National Highways Planning Response (NHPR 21-09) Formal Recommendation to an Application for Planning Permission

Council's Reference: 21/03267/OUT

Location: OS Parcel 0006, Southeast of Baynards House adjoining A43, Baynards Green

National Highways Ref: 92857

BOUNDARY SECTIONS 11-15

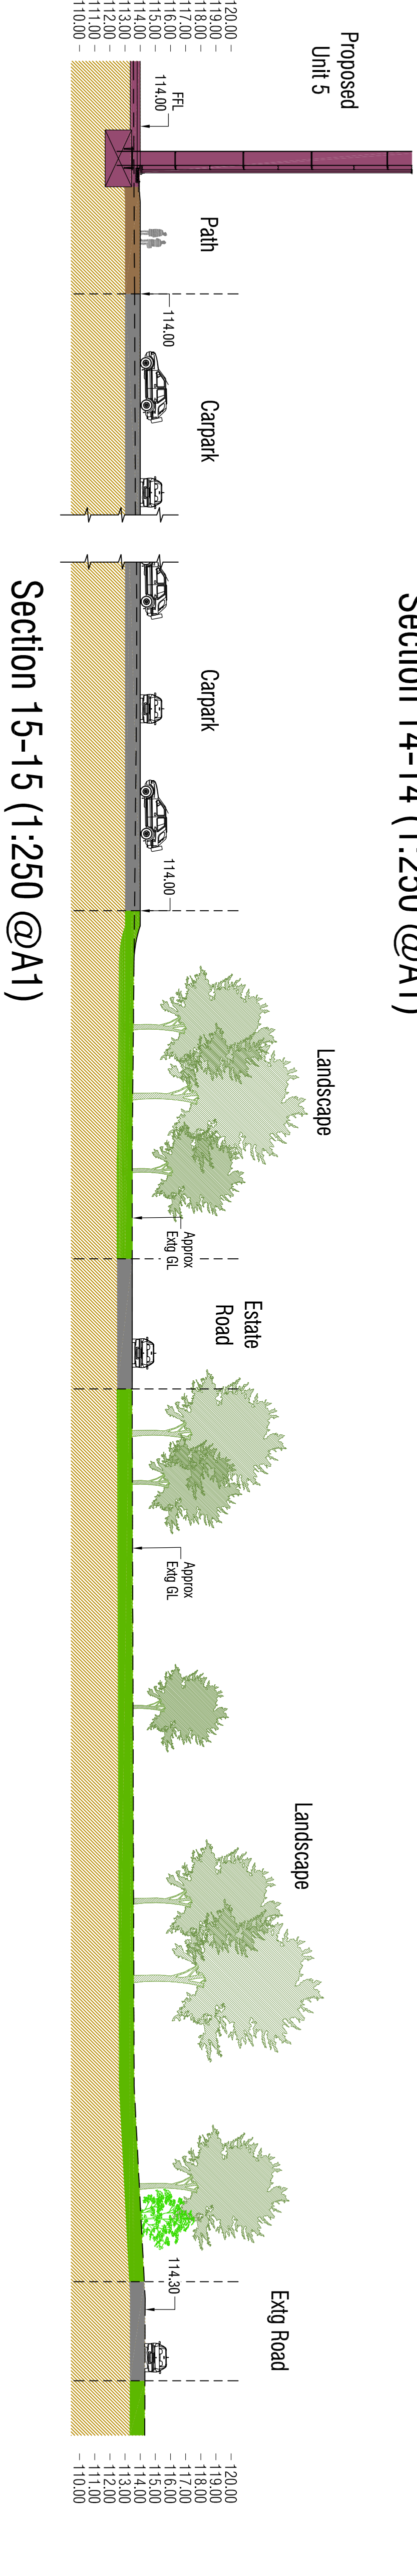
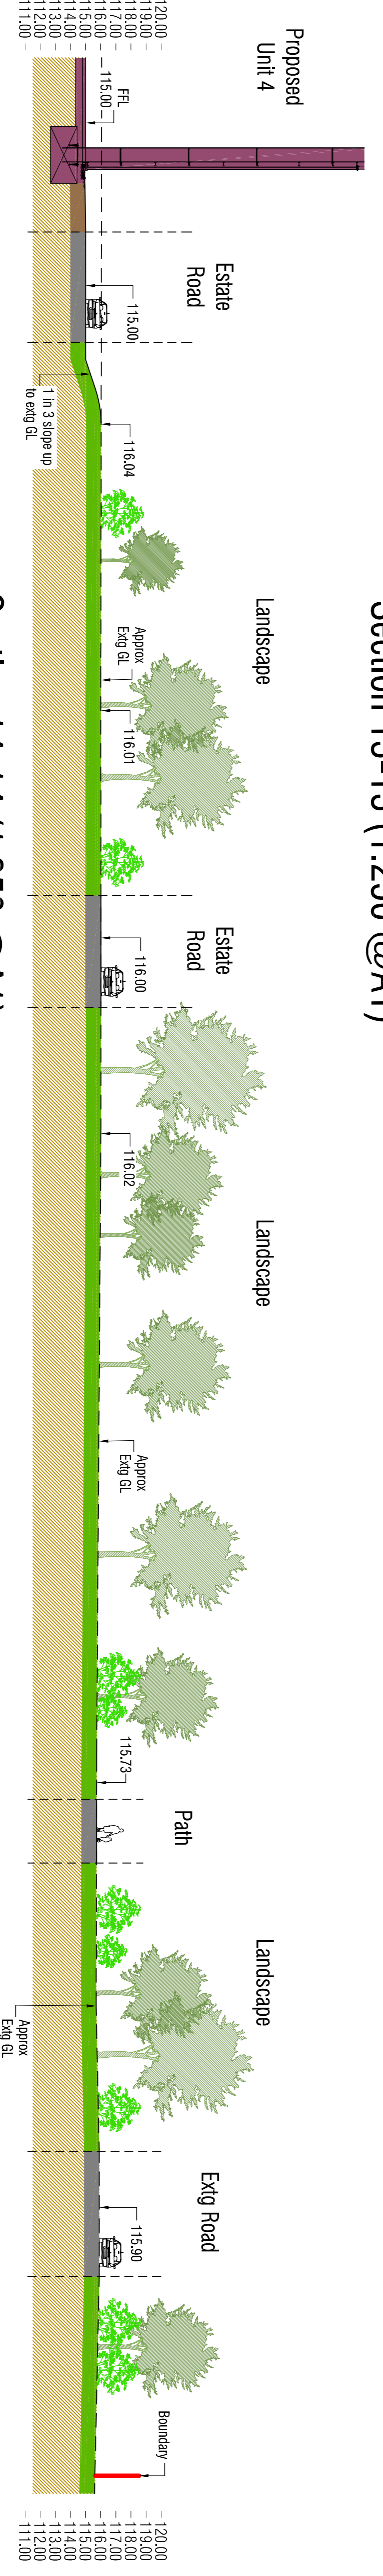
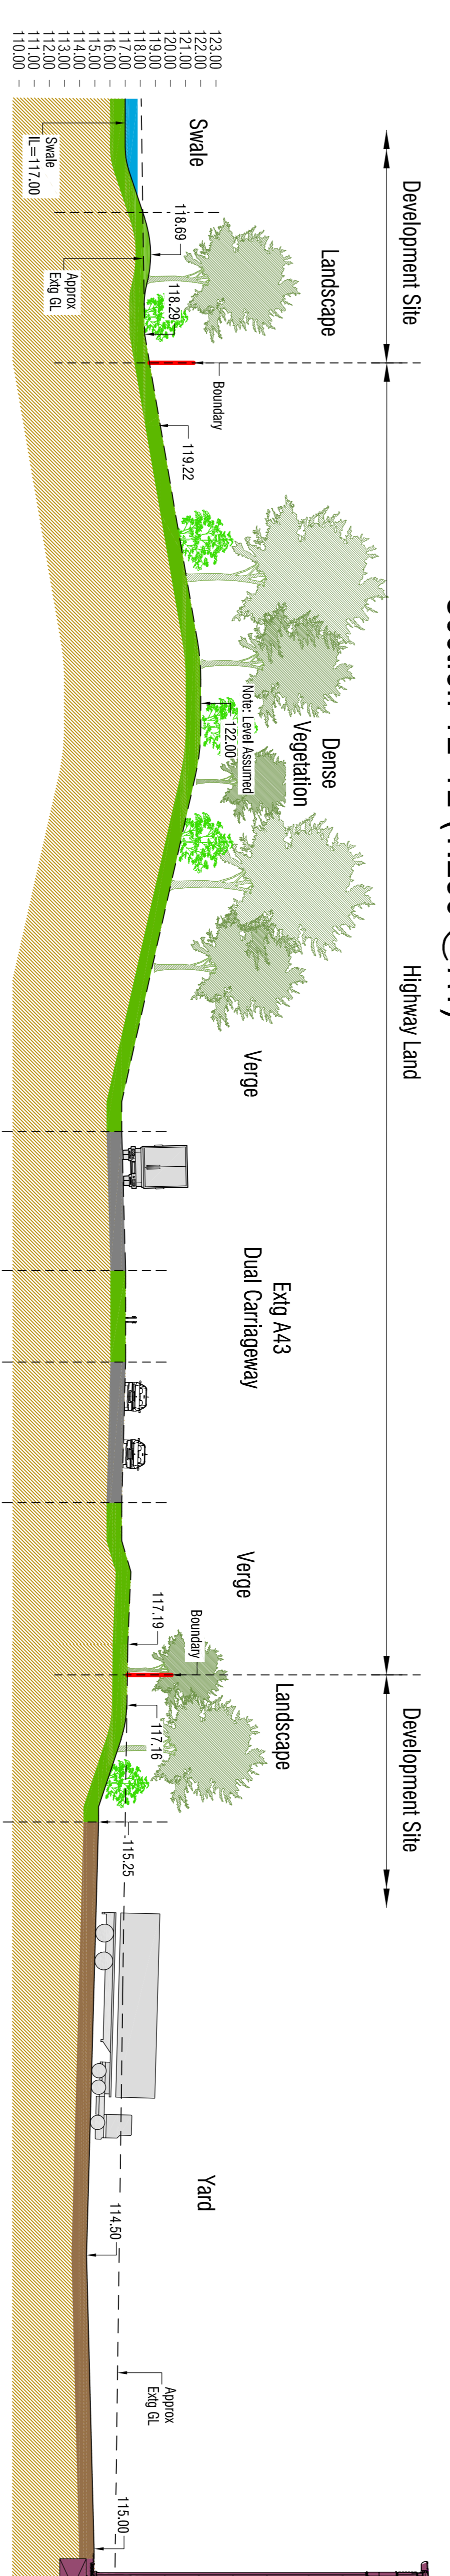
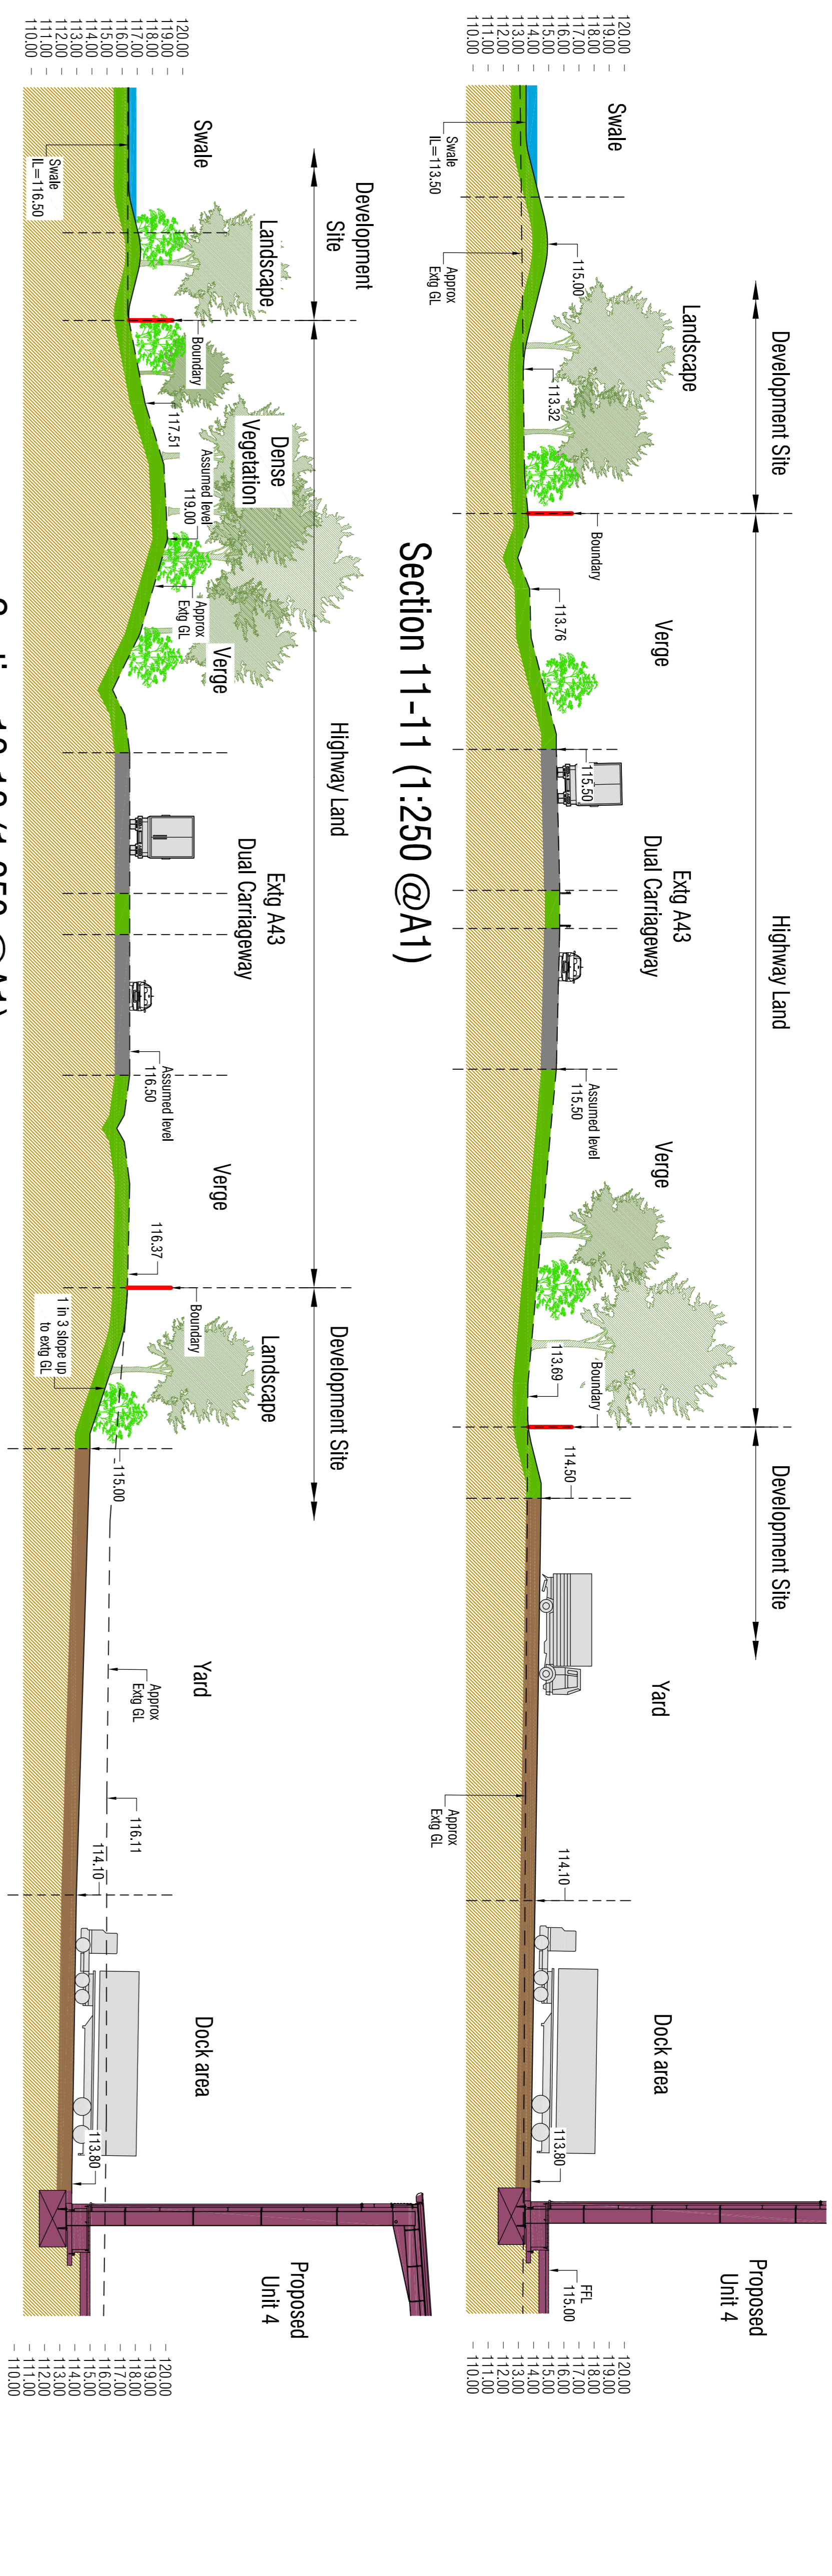
The applicant will need to advise / confirm if there will be any earthworks associated with the development(s) in relatively close proximity to National Highways boundaries (e.g. the stability of the balancing ponds, etc). In the first instance, some cross sections (to scale) through the boundaries showing the proposed extent of the development, its features and any proposed changes in elevation (excavations, landscaping) etc should be submitted for further assessment. Once received, we will review to determine the possible extent of any geotechnical reporting under the Design Manual for Roads and Bridges (DMRB) standard CD 622, which may be required to confirm the extent of any geotechnical risk to the SRN.
